Re: Cobbora Coal Project - Independent Groundwater Modelling Review

**PEER REVIEW OF THE COBBORA COAL
PROJECT GROUNDWATER ASSESSMENT**

Report Number: HC2012/5
Date: February 2012

Figure 4.5E Selected hydrographs showing observed versus calibrated transient groundwater heads

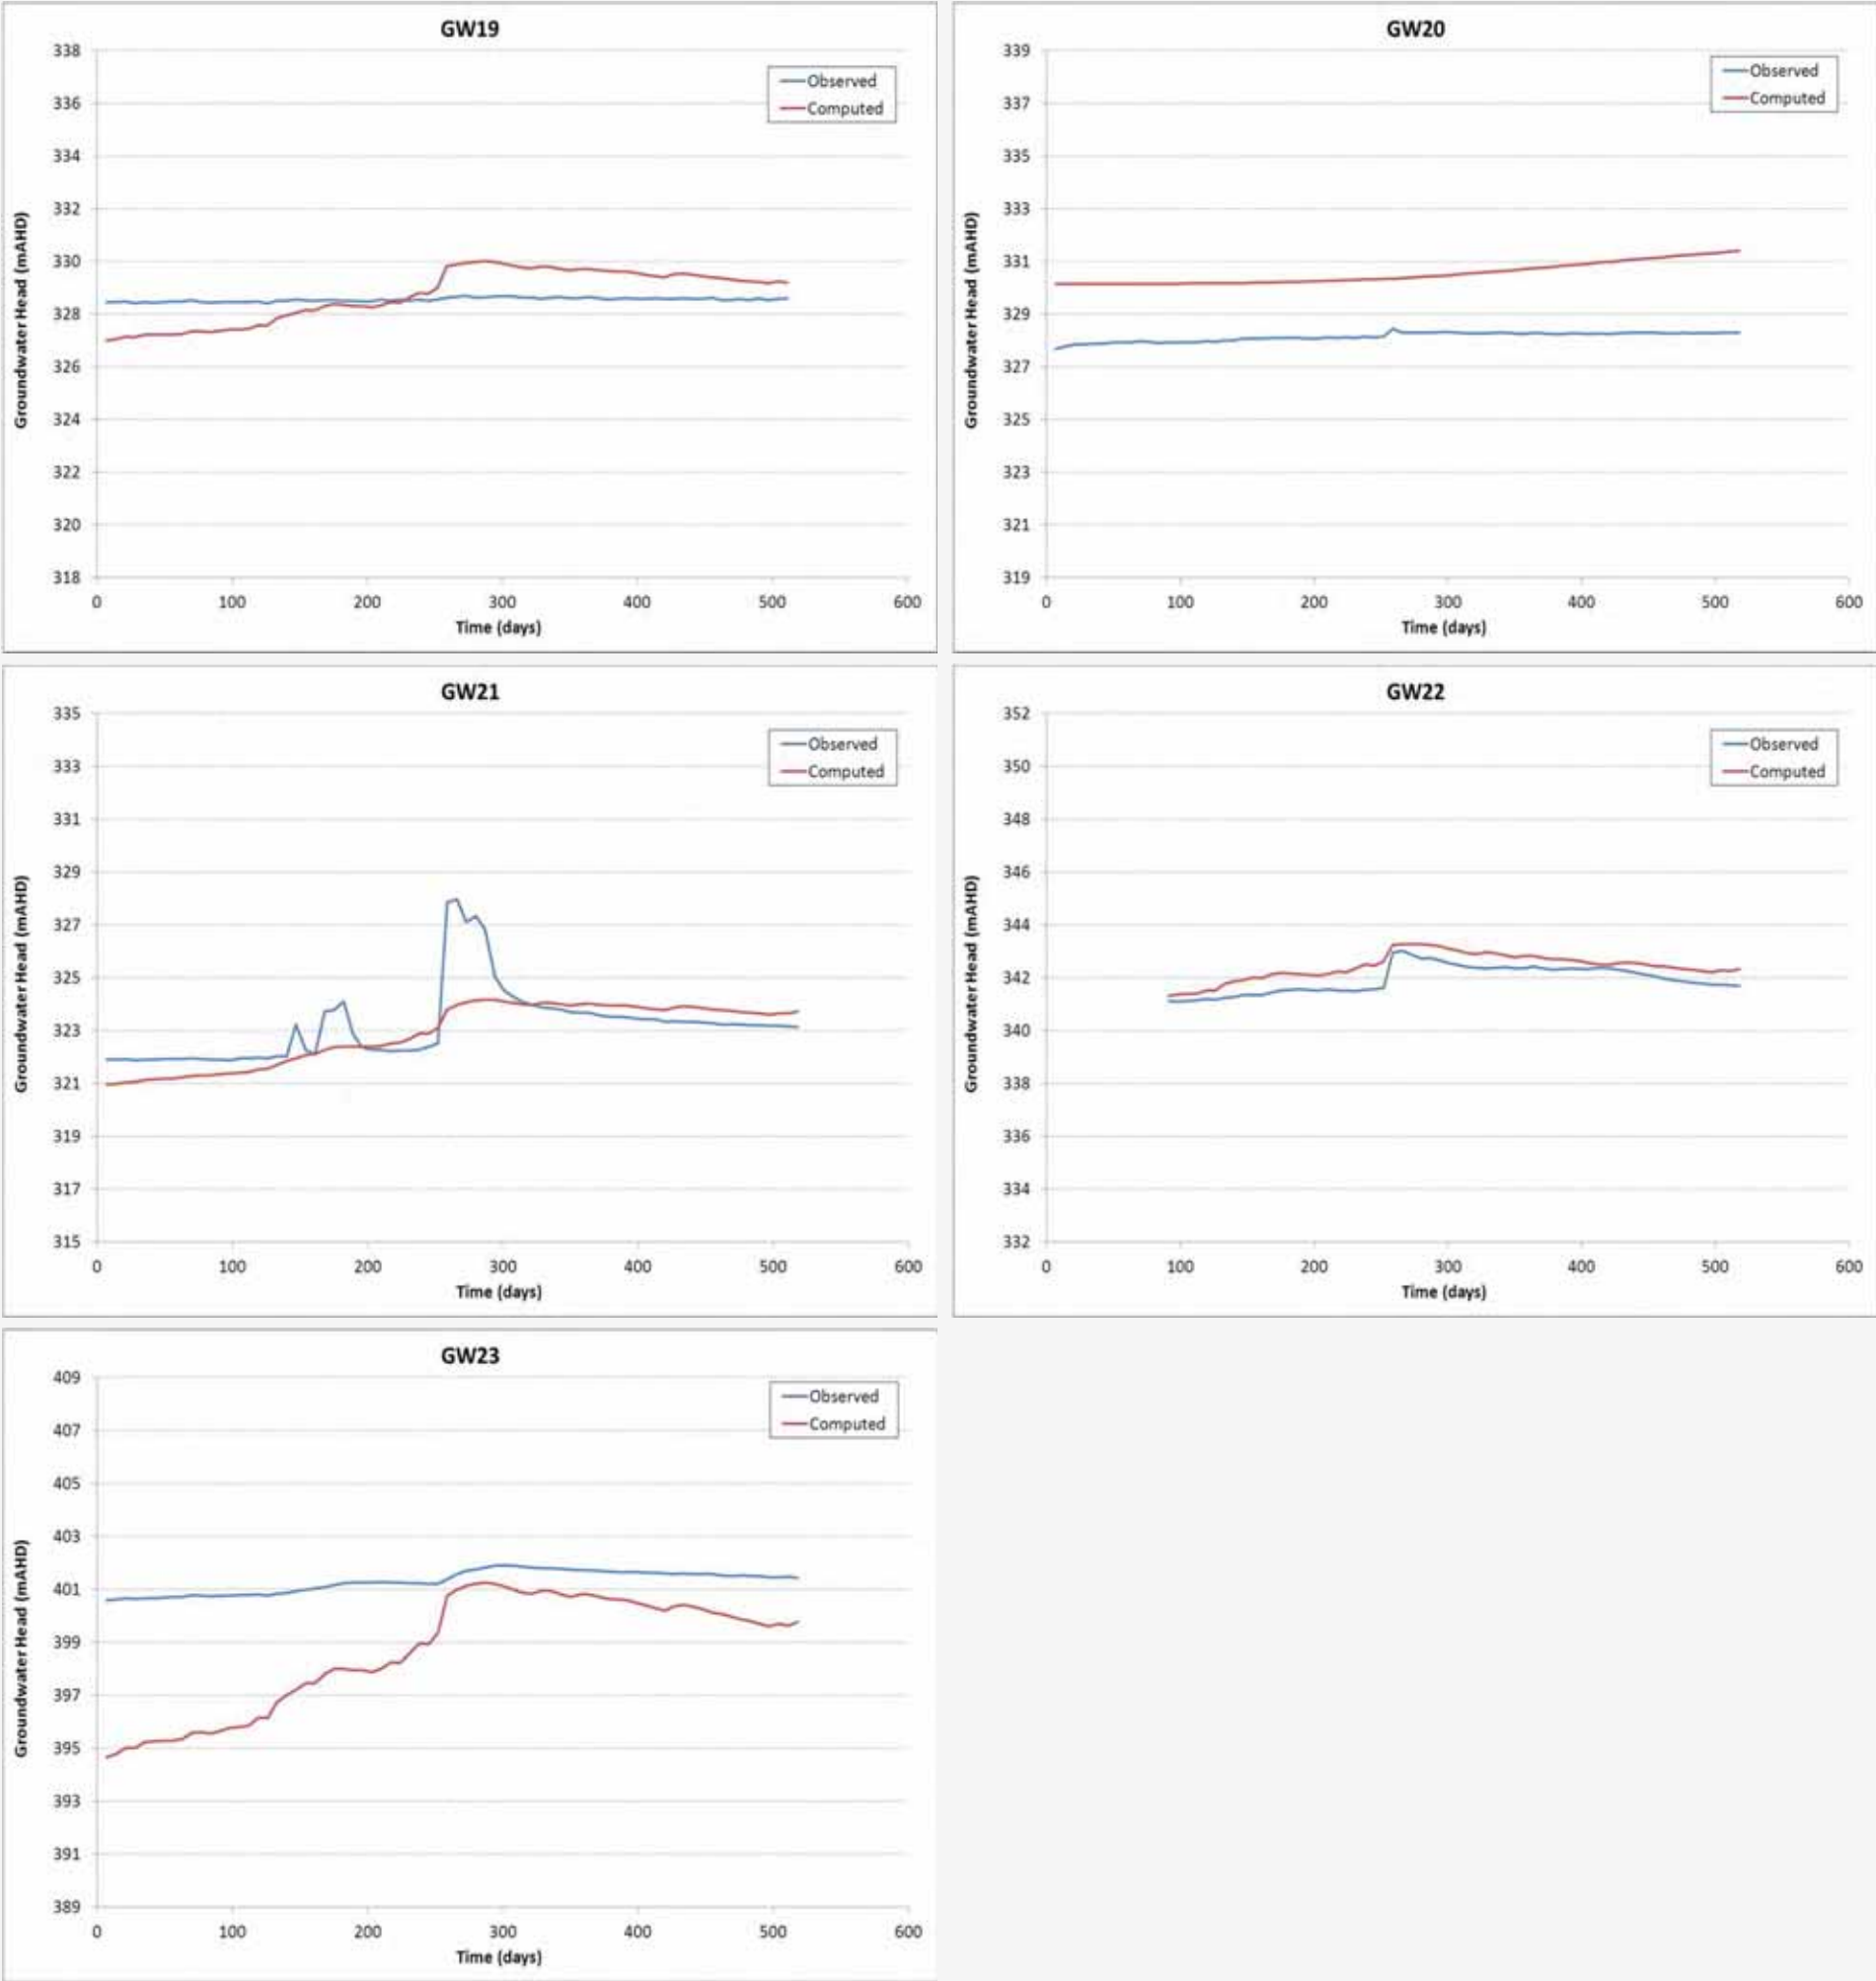
Transient calibration evidence is provided also by a scatter plot and RMS performance statistics, with examples of a few hydrographic matches. The transient performance is measured at 2.4 %RMS and 4.1mRMS, which is quite good. However, not all hydrographic matches are presented. Of the eight comparisons that are presented, only two are particularly good (in alluvium at Bore GW5A) and in the Digby Formation (at Bore GW5B). The others generally suffer from offsets in absolute value, although trends are

generally good. Without seeing the full set of hydrographic matches, or a residuals map, it is not possible to say which areas of the model are well calibrated or which natural processes are well replicated.
